**KIRKLEES METROPOLITAN COUNCIL
INVESTMENT & REGENERATION SERVICE**

Reference No: 2021/60/92462/W

Site Address: rear of, 1091, Manchester Road, Linthwaite,
Huddersfield, HD7 5LS

Description: Outline application for erection of detached dwelling

STATUS			PROVISIONAL		
PROJECT			LAND OFF 1091 MANCHESTER ROAD		
TITLE			PROPOSED		
CLIENT			P.WHITING		
DRAWN BY	CHECKED BY	DATE			
Author	Checker	12.05.2021			
SCALE (@ A1)		PROJECT NUMBER			
As indicated		HD.20.33			
DRAWING NUMBER				REV	
HD.20.33.01

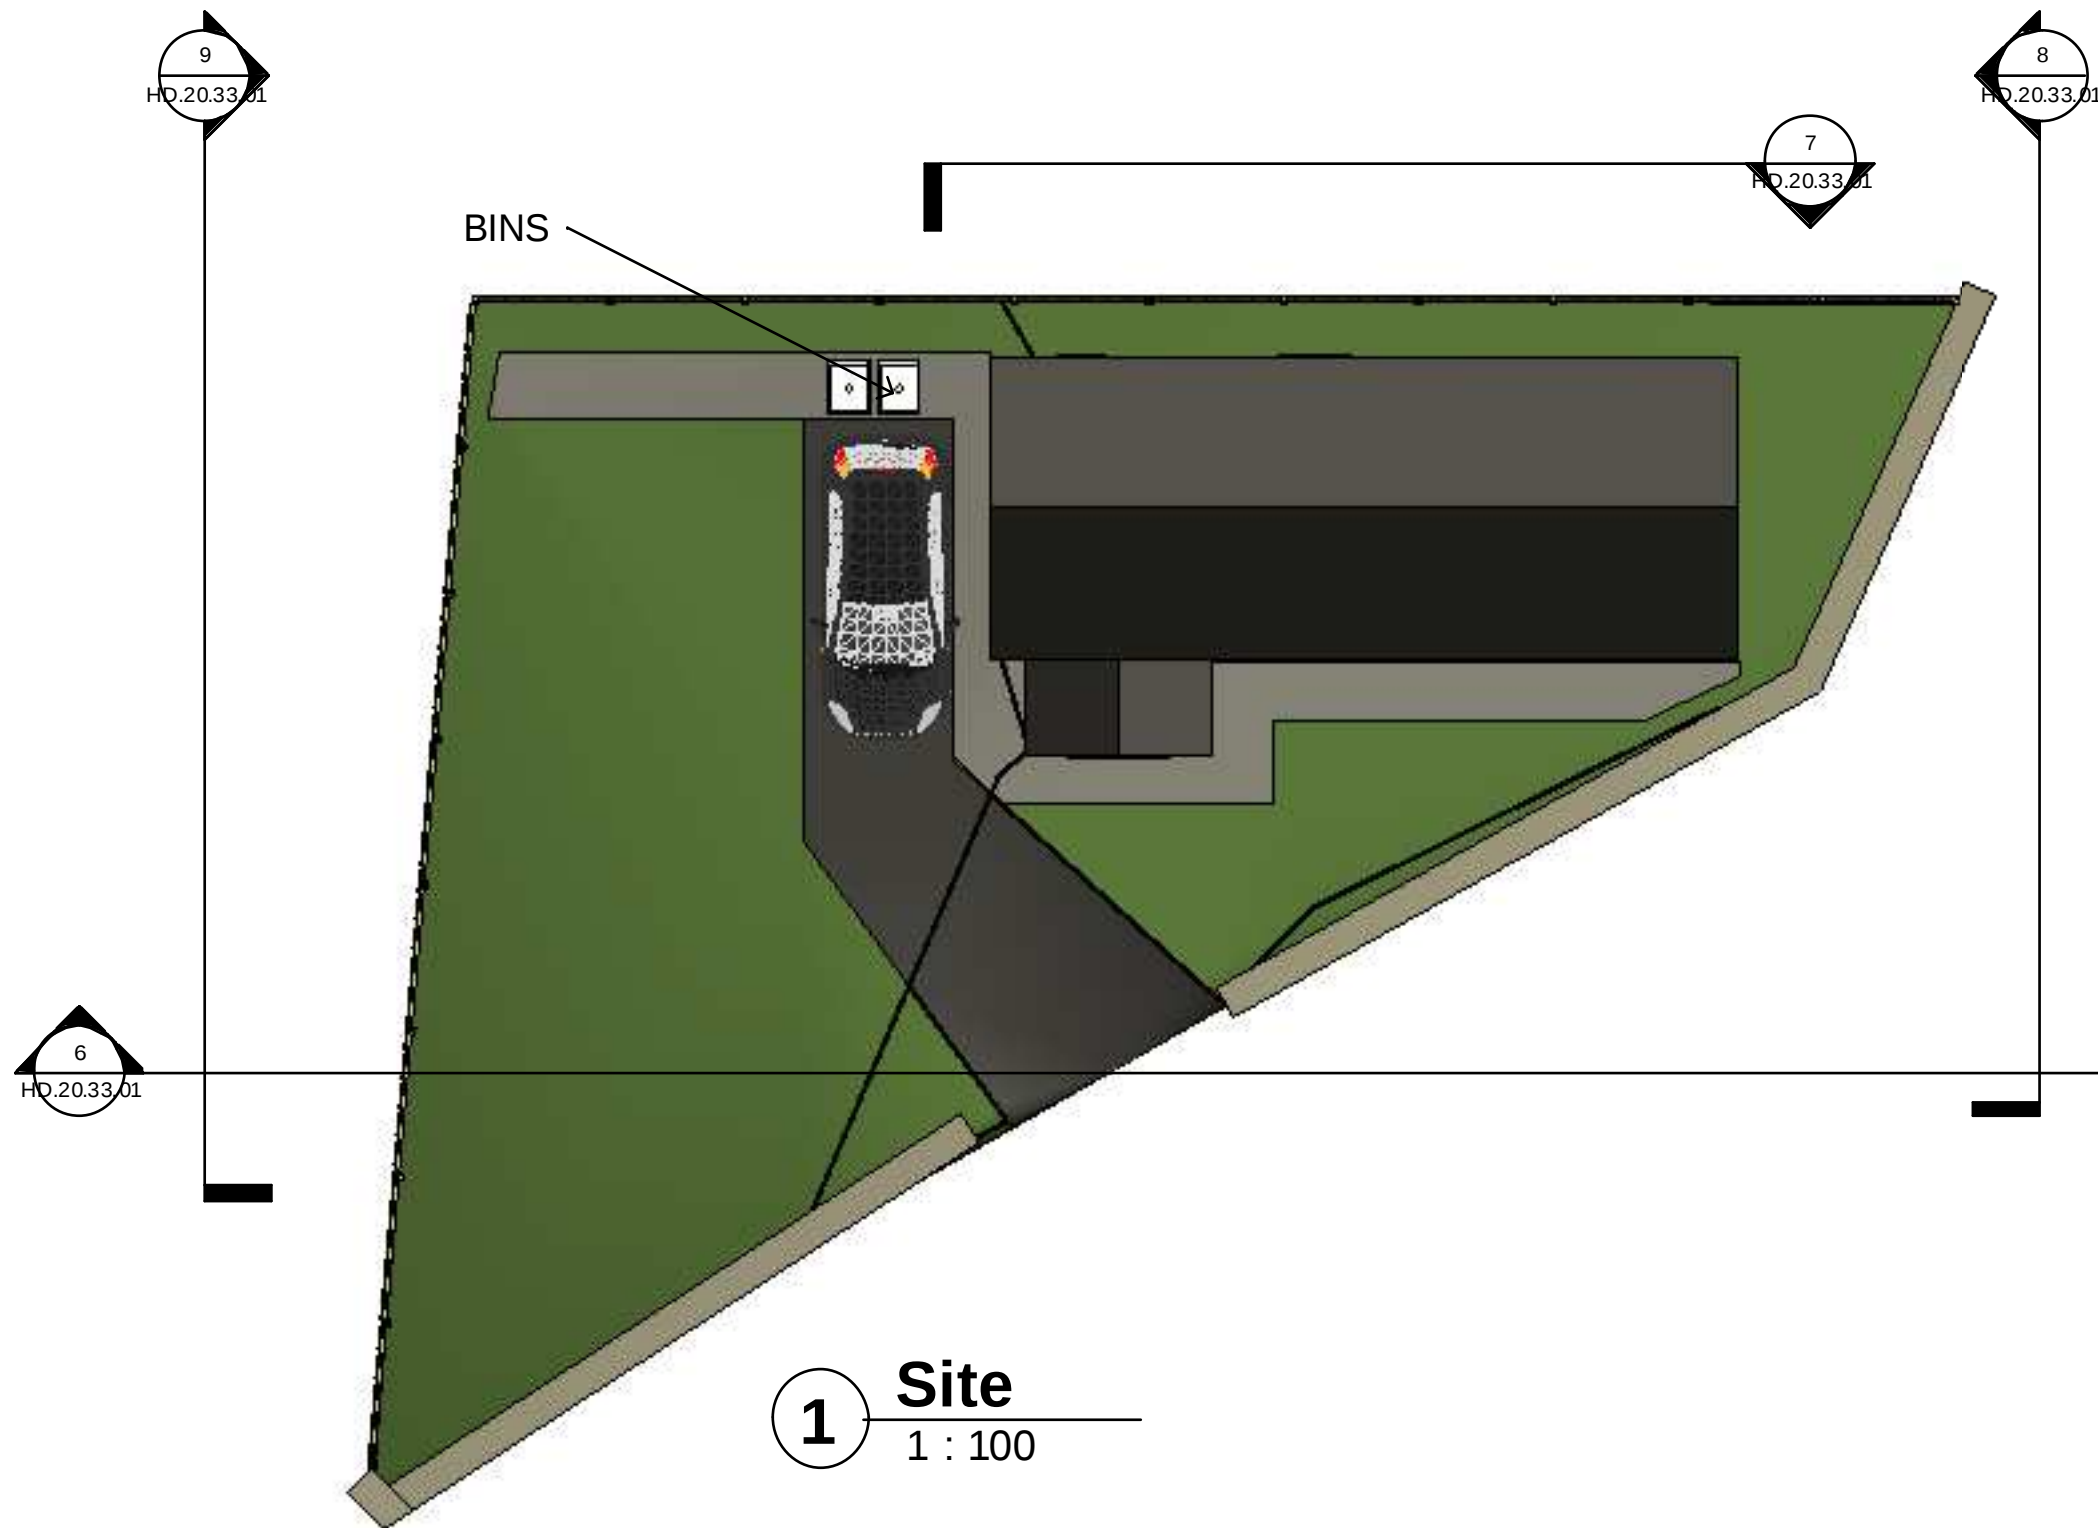
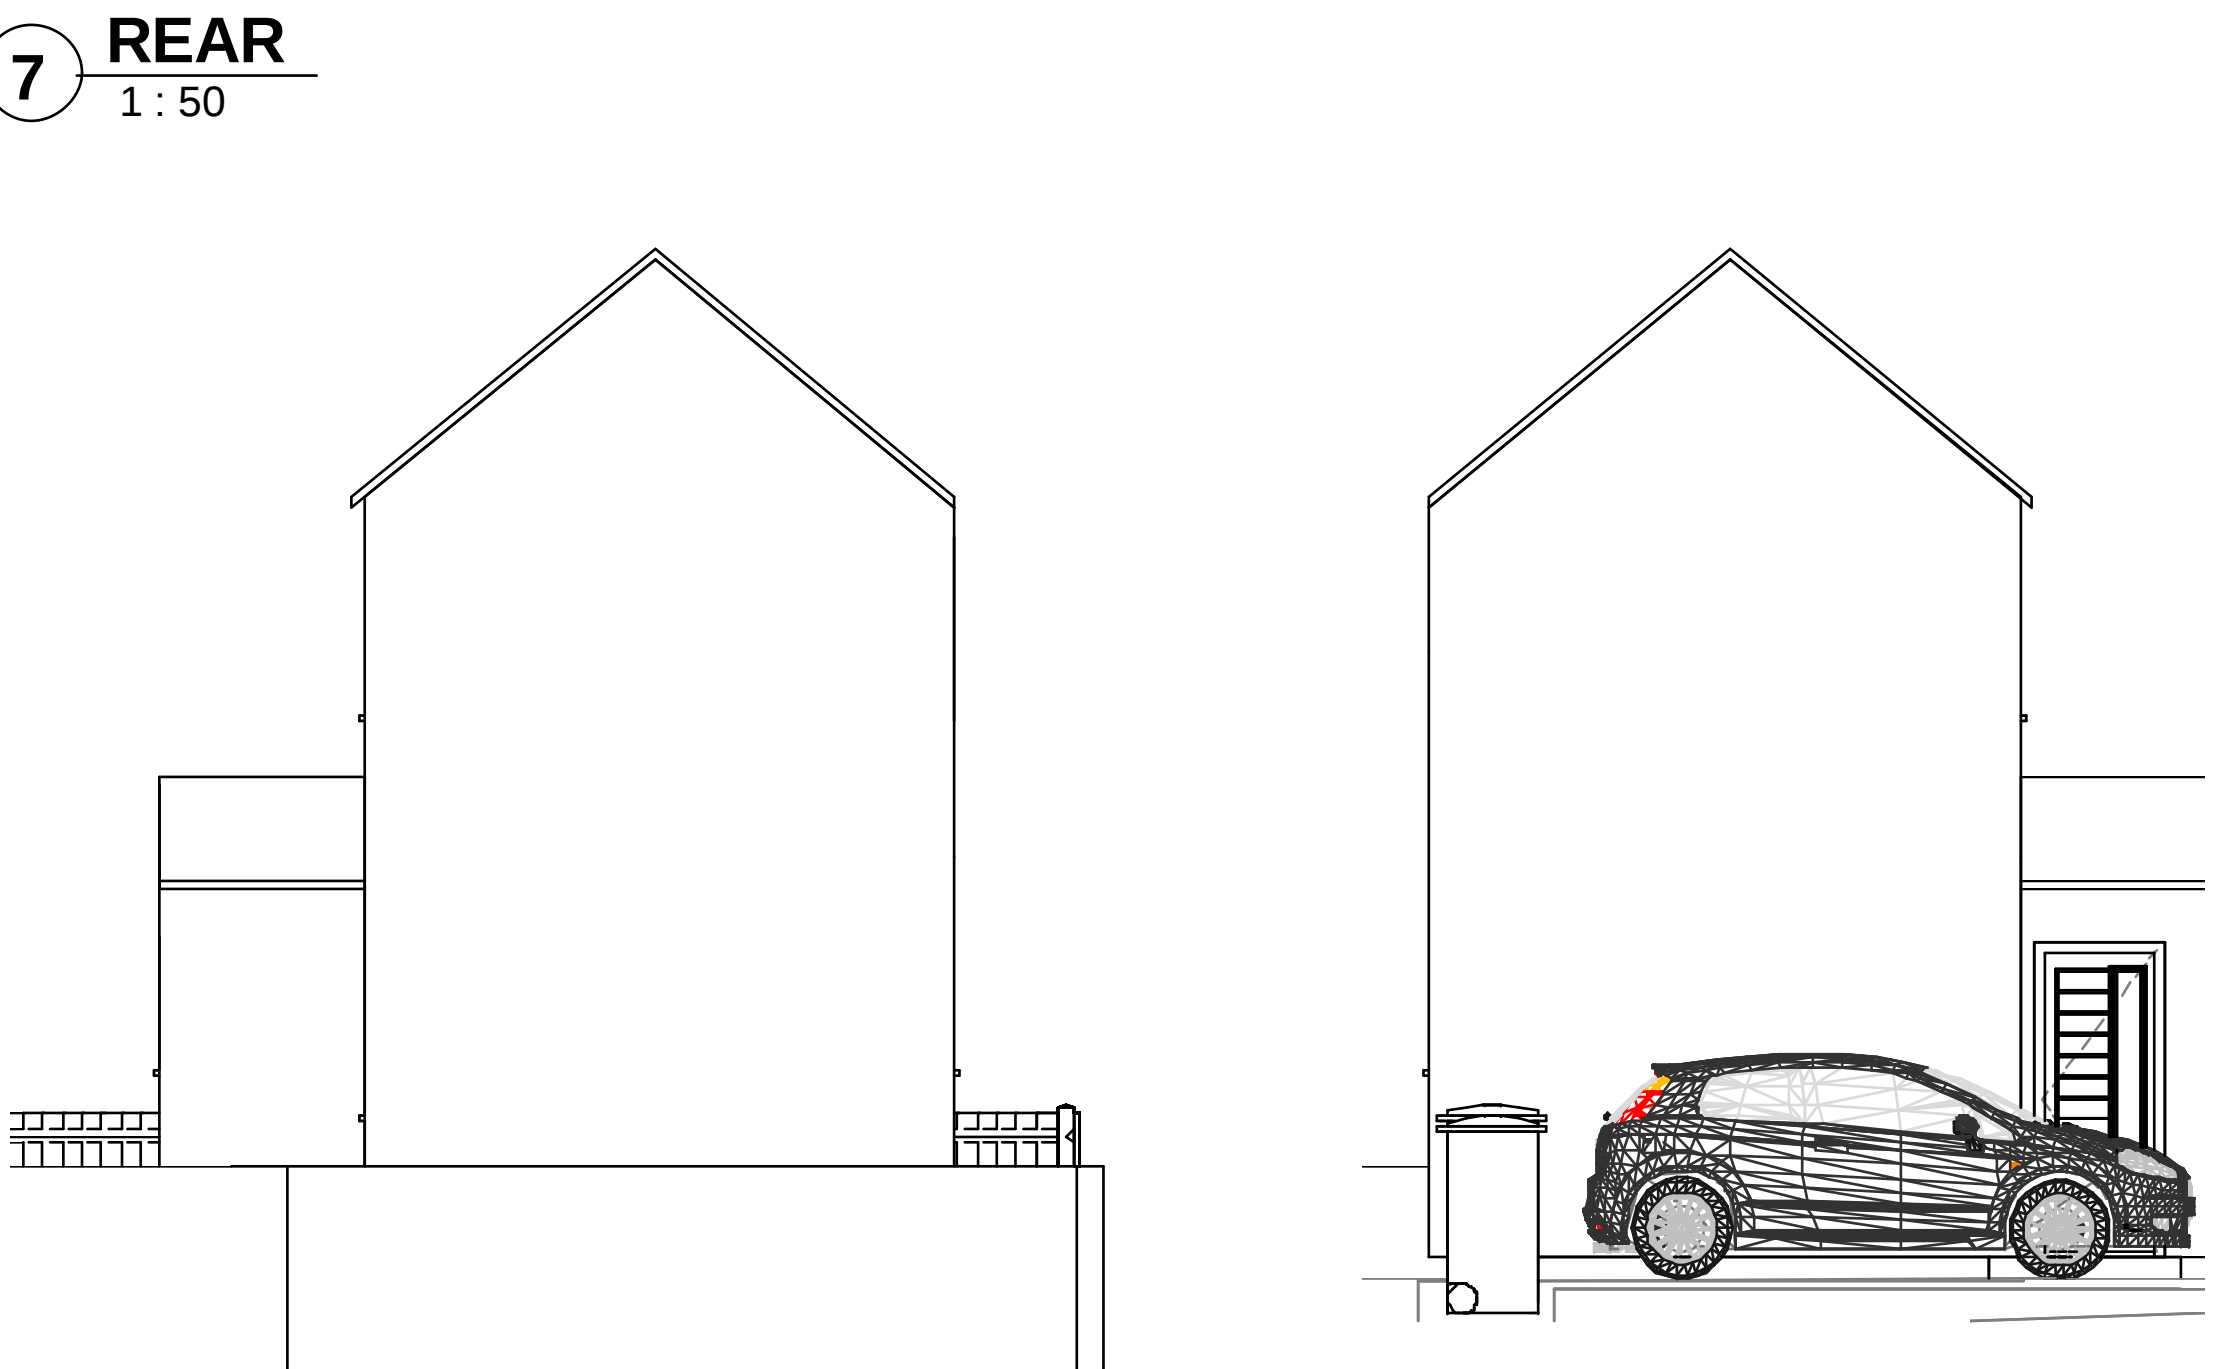
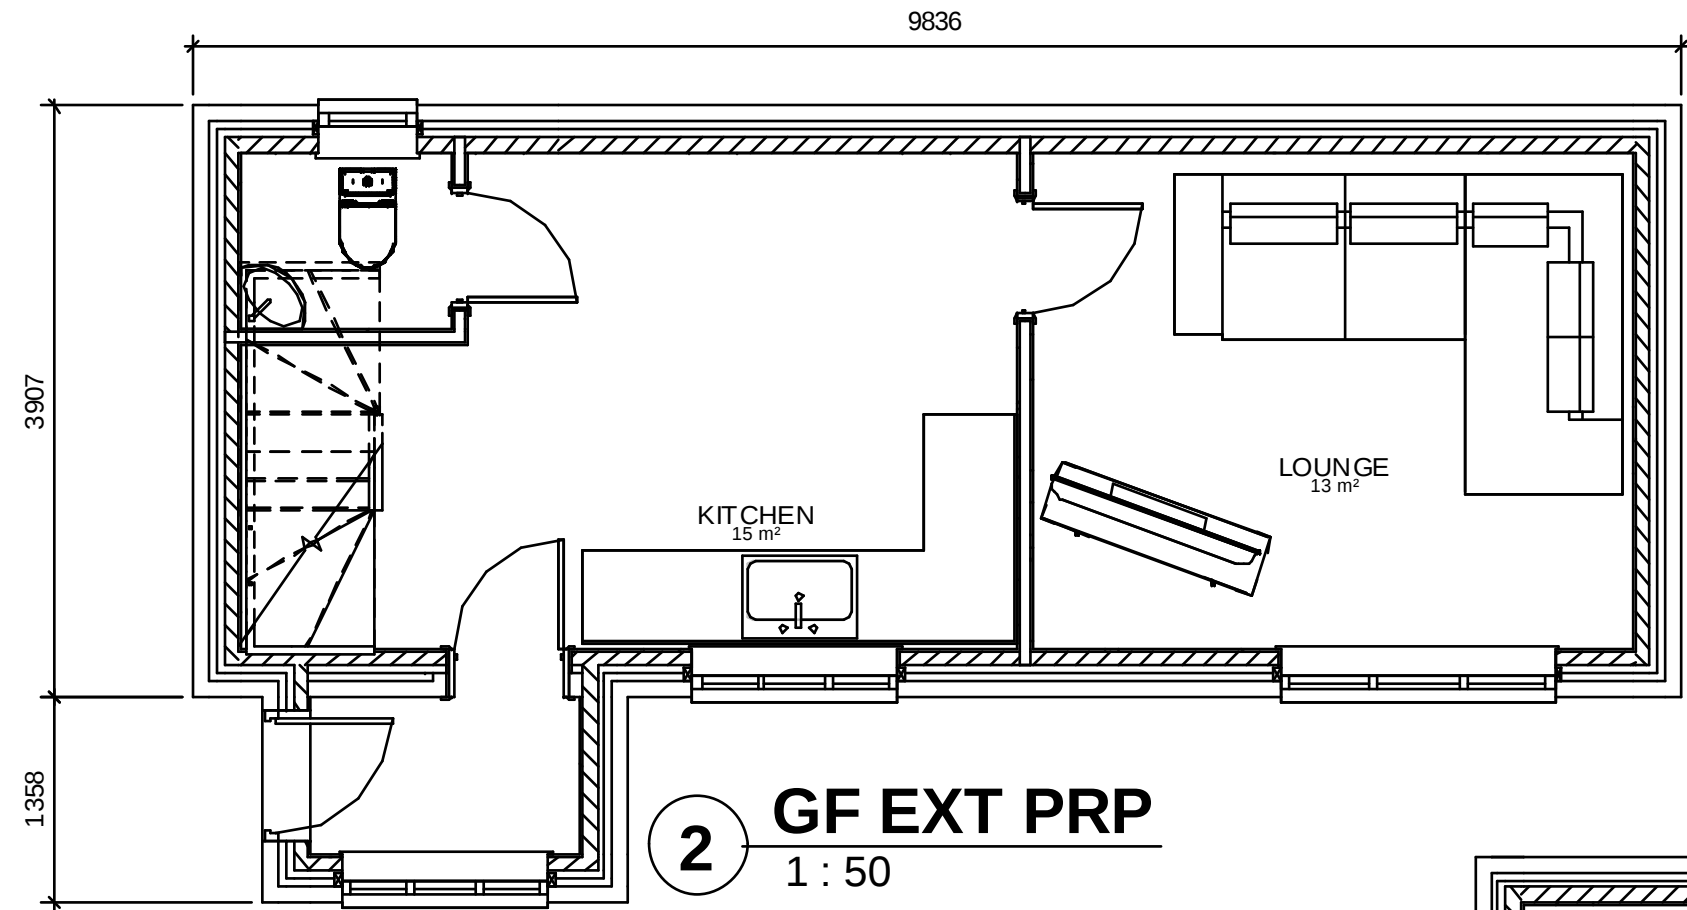
The application site is considered to be small for a dwelling at 195 square metres, with its triangular shape further restricting the potential for the suitable development of the site. It has been noted that the indicative layout now proposes a smaller dwelling, with only two bedrooms and one off street parking space. The dwelling is to be placed towards the southern end of the

site but would still be situated 0.3m from the boundary edge. More specifically the internal floor space has been measured at 64 sq. m, which is a slight reduction from the previous scheme, however, this raises concerns from an amenity perspective. Therefore, whilst layout has not been applied for, the indicative details are considered likely and these highlight that the erection of a dwelling on the site would appear cramped and would provide a poor level of amenity for its future occupants.

As such, it has still been considered that the proposed development would have a significant overbearing and oppressive impact upon these neighbours amenity, along with their outdoor amenity space. This is due to the sloping nature of the site, which would result in any potential development being on a greater level than these neighbours. With regards to the indicative plans, these show a two storey dwelling to be proposed, which would be within 10m from the nearest elevation at no. 3 and 14m from no. 5.

Whilst officers acknowledge that the plans submitted as part of this proposal are indicative, they provide a reasonable demonstration to the level of internal floor space likely to be achieved. In this case, the development proposes a two storey, two bedroom dwelling in which would have an internal floor space, significantly below the governments technical housing standards at 64 sq. m. This would be 15 sq. m below the national guidance and would be contrary to paragraph 9.1 of the Council's Housebuilders Design Guide SPD. This therefore demonstrates that an appropriate level of amenity cannot be created, in a way that does not result in the overdevelopment of the site.

1. The proposed residential development, in relation to plot size and taking into account its relationship with surrounding development, would represent a cramped form of development constituting an overdevelopment of the site. It would fail to add to the overall quality of the area or result in a scheme that is visually attractive. Furthermore, the proposal, would fail to preserve or enhance the setting of the neighbouring listed buildings, by occupying a substantial part of the existing open space, which is currently used to contrast with the built form and to provide views of the listed buildings, particularly those to the North. The development would therefore cause harm to the significance of the designated heritage assets and to the wider visual amenity of the area. No public benefits have been put forward to outweigh the identified harm to the setting of the listed buildings. The development would therefore be contrary to the Council's duties under the Planning (Listed Buildings and Conservation Areas) Act 1990, policies LP24a and LP35 of the Kirklees Local Plan, Principle 2 and paragraph 6.12 of the Council's Housebuilders Design Guide SPD and Chapters 12 and 16 of the National Planning Policy Framework.

2. The proposed residential development, when taking into account the changes in topography in the surrounding area and the close proximity between the application site and the principal elevations of 1, 2, 3, 5, 7 and 9 Linfit Fold, would have a significant overbearing and oppressive impact upon these neighbours amenity and outlook and could potentially lead to detrimental overlooking. This would not provide a high standard of amenity for neighbouring occupiers, contrary to Policy LP24(b) of the Kirklees Local Plan, Principle 6 of the Council's Housebuilders Design Guide and paragraph 127(f) of the National Planning Policy Framework.
